Response to Planning application from Hertfordshire County Council (T and CP GDP Order 2015)

District ref: 6/2023/1433/COND
HCC ref: WH/17534/2023
HCC received: 14 July 2023
Area manager: Manjinder Sehmi
Case officer: Chris Carr

Salisbury Square Hatfield AL9 5AD

Submission of details pursuant of condition 2 (construction management plan) on planning permission 6/2021/3422/MAJ

Drawing No
221111-CON-XX-00-DR-C-6000

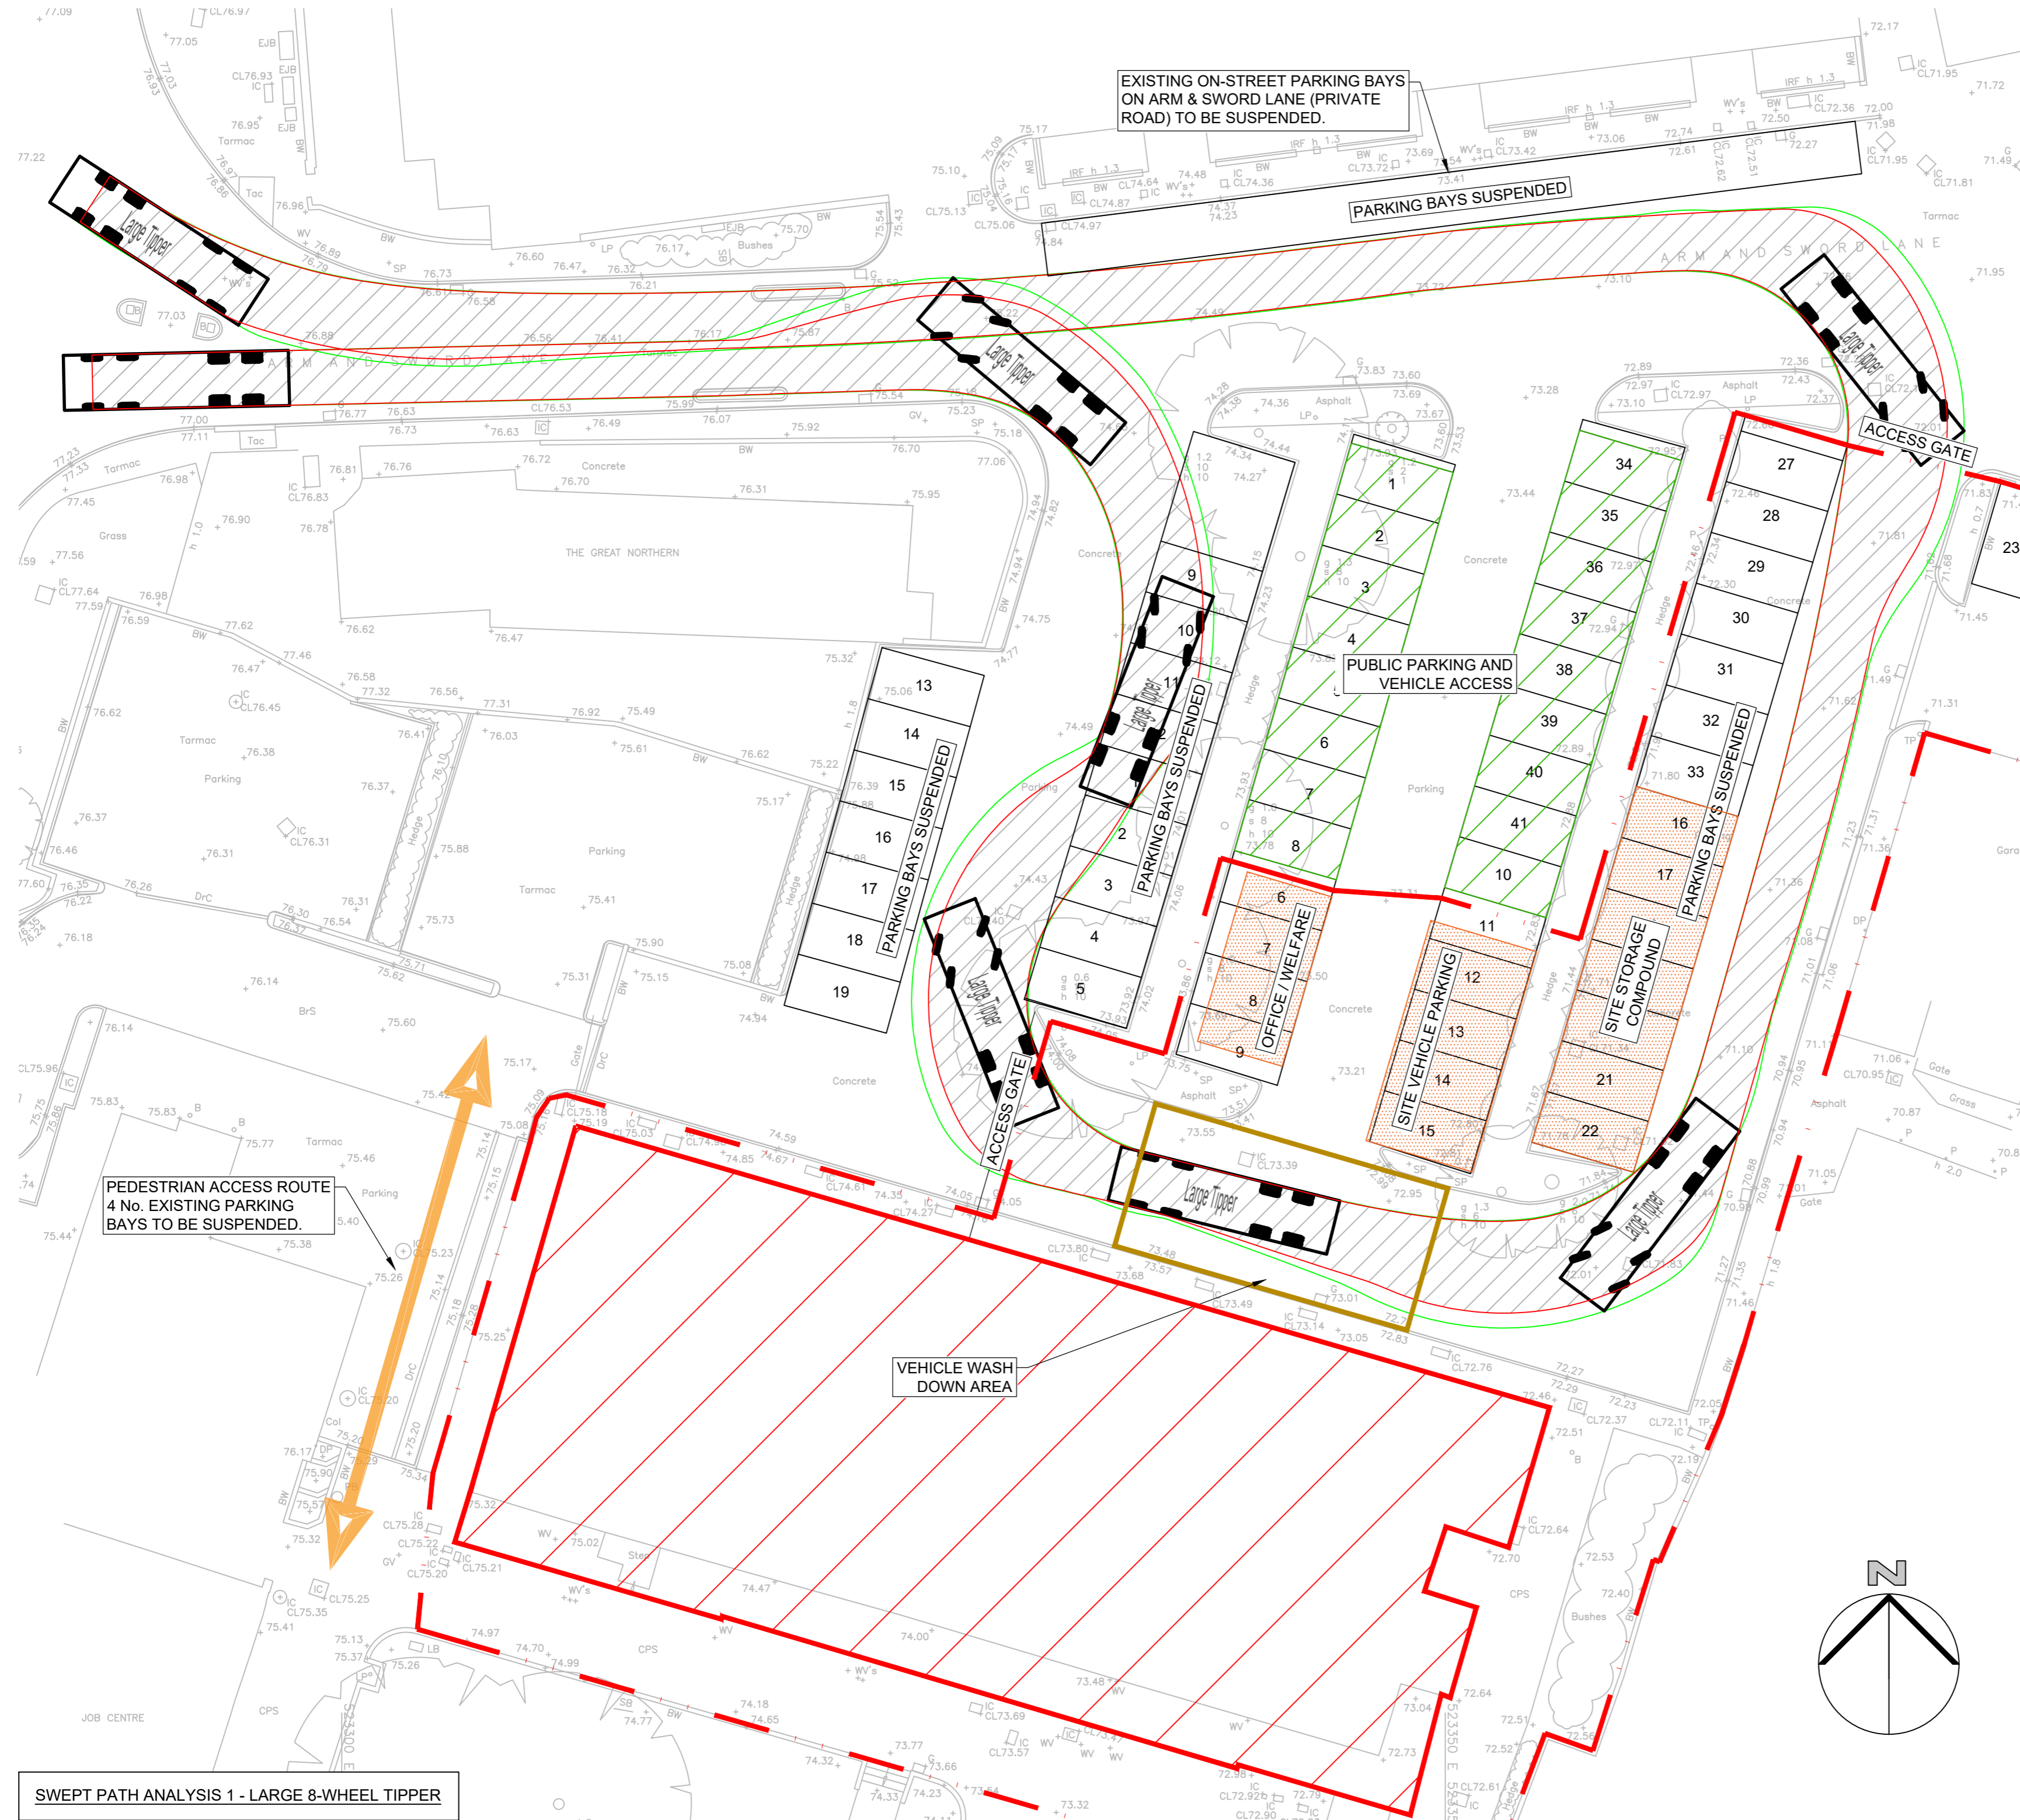
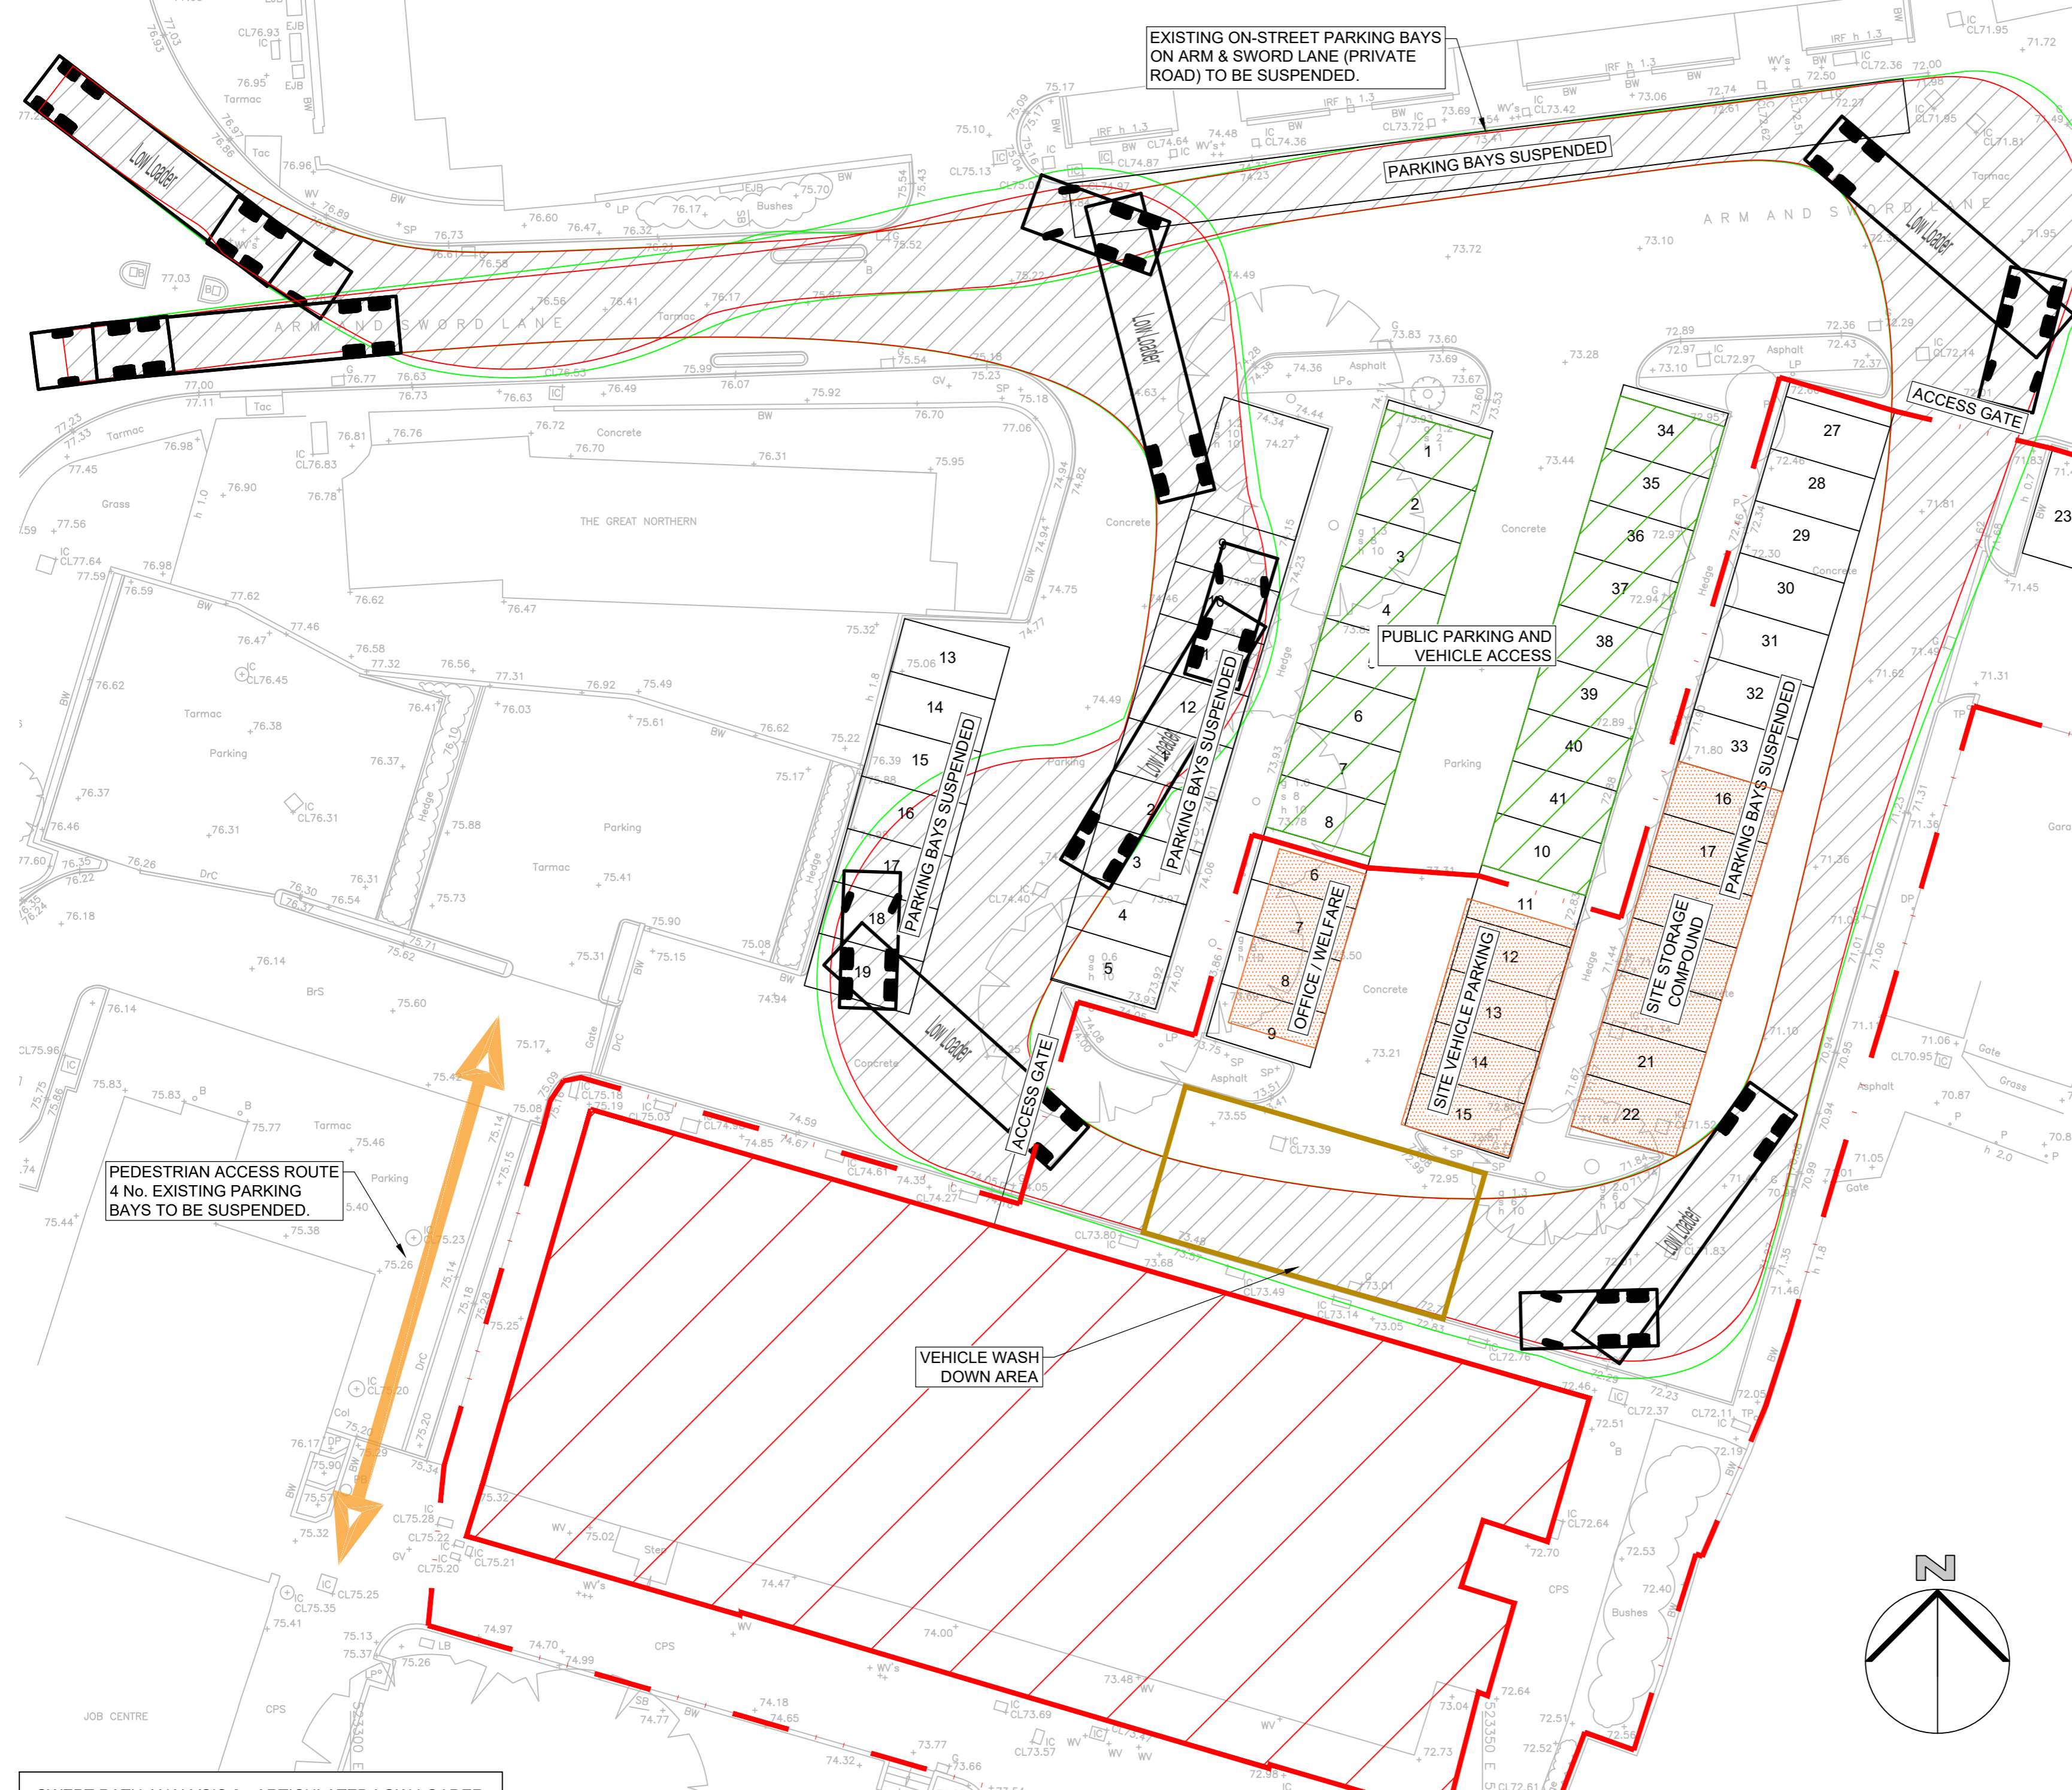
a) The CMP includes details of the expected vehicle numbers and types of vehicle. The largest vehicle expected is a 16.15m long low loader. The applicant has submitted swept path analysis (drawing 221111-CON-XX-00-DR-C-6000-P02) showing a large tipper (10.2m long) and a long low loader (16.15m long) entering and exiting the construction site in forward gear. Directly opposite the construction access is existing on-street parking along Arm and Sword Lane. The swept path analysis shows that the long low loader vehicle would only be able to access and exit the site if these existing parking spaces were unoccupied. There are no details provided in the CMP with regards to whether these parking bays would be temporarily suspended. Therefore it is assumed that based on this existing parking, the proposed construction vehicles would not be able to enter and exit the site. Therefore updated swept path analysis is required.

b) During construction, it is proposed that vehicle access will be via Arm and Sword Lane at the rear of the site. As previously mentioned, the swept path analysis provided is unacceptable as access for the largest vehicle is restricted by existing on-street parking. This therefore needs to be updated. The CTP confirms that Banksman will be posted at the site entrance to protect pedestrians or warn approaching traffic whilst marshalling wagons or delivery vehicles on/off the site. This is considered acceptable. Pedestrian access to Salisbury Square public realm is immediately adjacent to the west and east of the parade. It is proposed that there would be disruption only to the access route through the car park to Horse and Groom Pub and this will be reinstated at completion of the works.
